From: Ross McLeay <rmcleay@ausgrid.com.au>
Sent: Tuesday, 24 February 2015 10:10 AM
To: Pilar Aberasturi
Subject: Fw: TRIM: D15/125353 - MP10_0016 MOD 1, 2 Cooper St Paddington

From: Ross McLeay/Ausgrid
To: pilar.aberasturi@planning.nsw.gov.au
Date: 19/02/2015 12:03 PM
Subject: TRIM: D15/125353 - MP10_0016 MOD 1, 2 Cooper St Paddington

ELECTRICAL SERVICES
EXTERNAL SITE PLAN

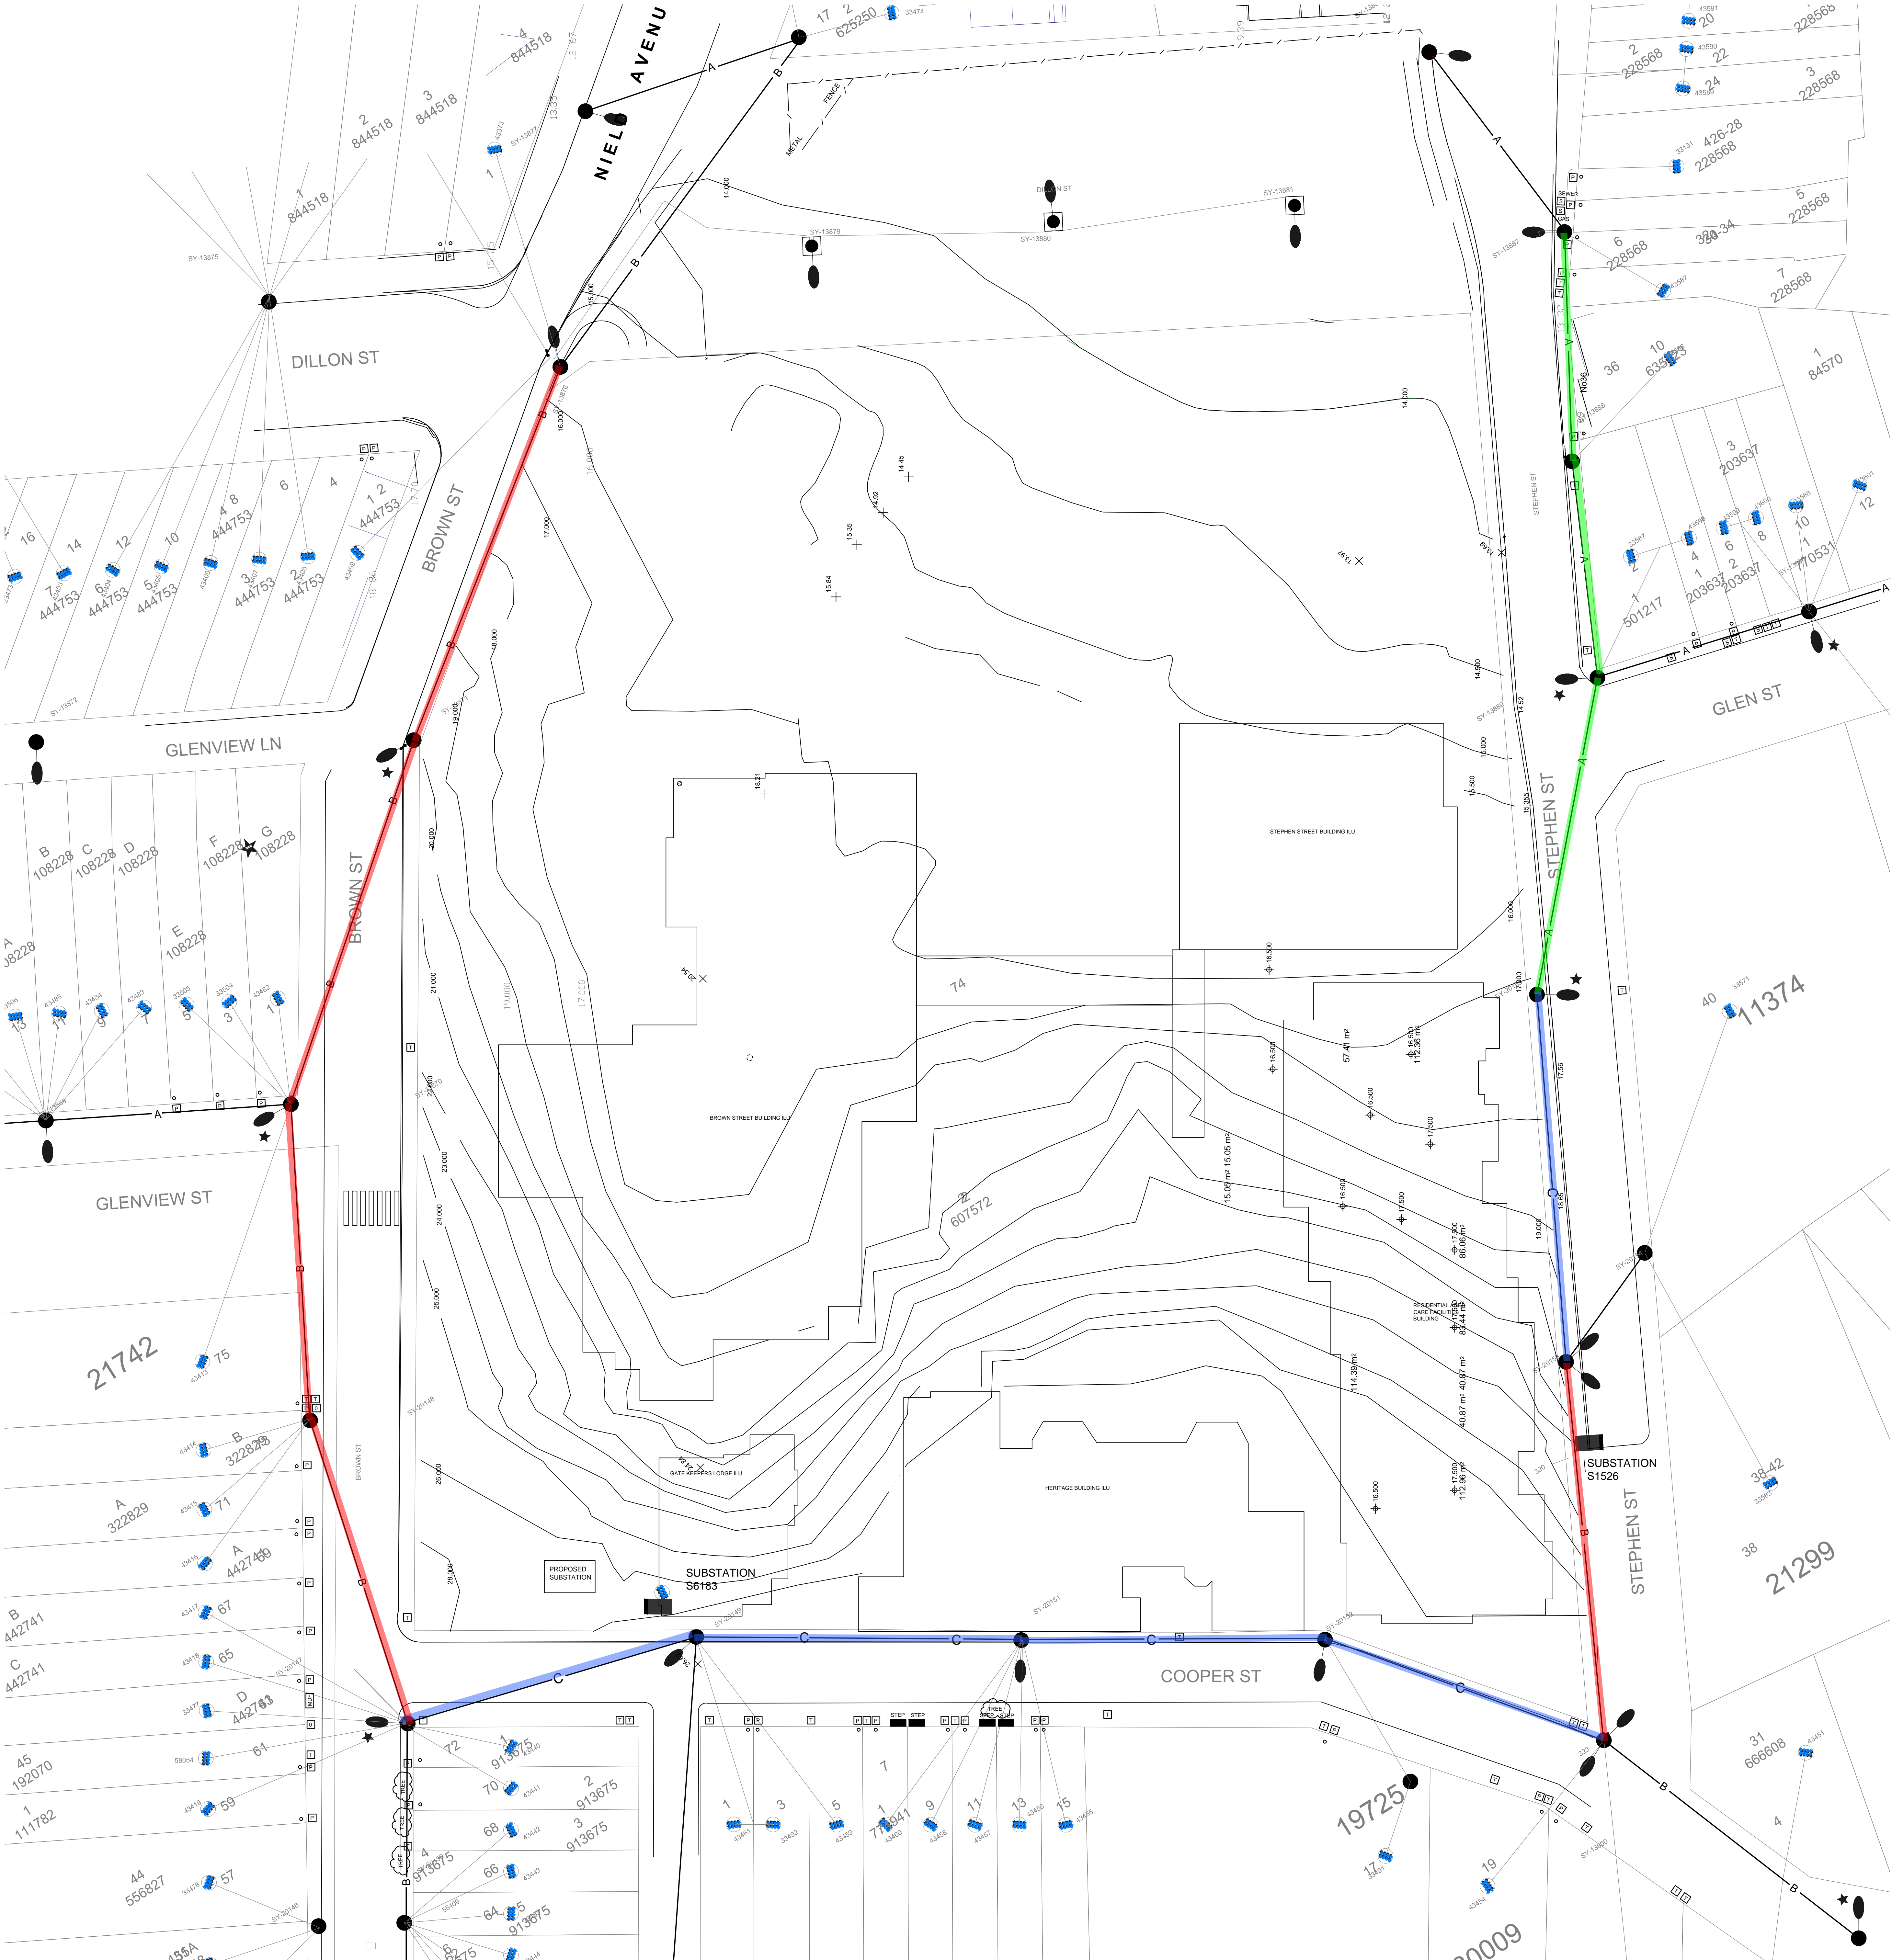
The 5th dot point on page 3 of the urbis letter states there would be "additional new dedicated street lighting poles" our records indicate that not every pole around the development site has a street light on it at present. Hence there would be less poles than present to maintain existing lighting levels.

There is a reference to "the approach already undertaken by Ausgrid" ie bundling. The most likely reason parts have already been converted to ABC is to reduce required tree trimming. Please note the use of bundled cable does not remove the need for tree trimming. The cost to underground cables is higher than bundling hence why that option would have been chosen, however as per Ausgrid publication Network Standard 110 Clause 3; *Electricity recalculation systems in new residential subdivisions must be installed underground...*

Whether under-grounding or bundling is chosen the extent of the works will be nominated by Ausgrid as it is sometimes necessary to extend the works further than requested to ensure the reliable operation of the network.

Hello Pilar,
as per our discussion, Ausgrid has no objection to the proposed changes to the DA ie removing the requirement to underground the wires and adding a requirement to convert existing open wire overhead to Arial Bundled Conductor (ABC) overhead.

Figure 2: Ausgrid LV Network Pillar

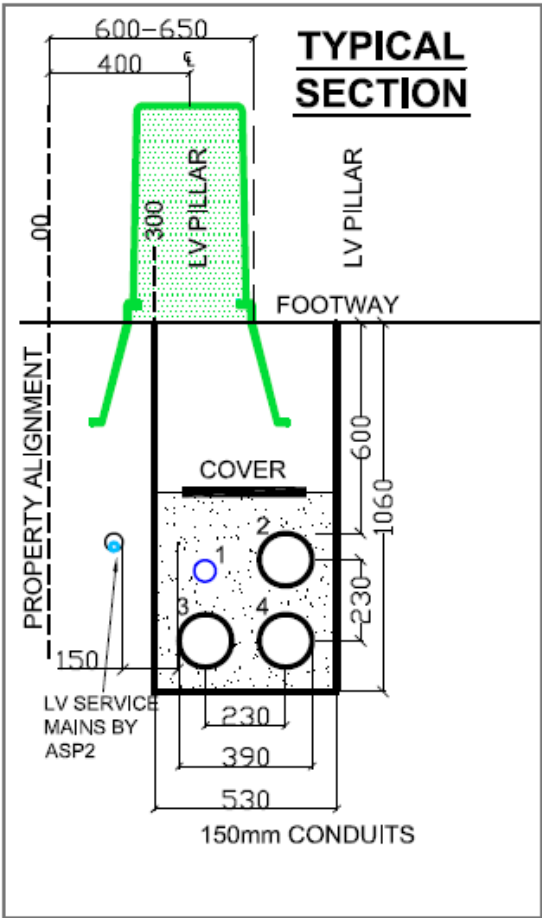
Page 1
dot point 1 refers to an image of a pillar with substantial graffiti, as per our web site; Ausgrid aims to keep its network assets free of graffiti vandalism and our policy is to remove graffiti vandalism from substations or other assets within seven working days of it being reported
dot point 2 in regard to disrupting the tree root protection zone Ausgrid Publication NUS174c (Environmental Handbook) addresses this issue.
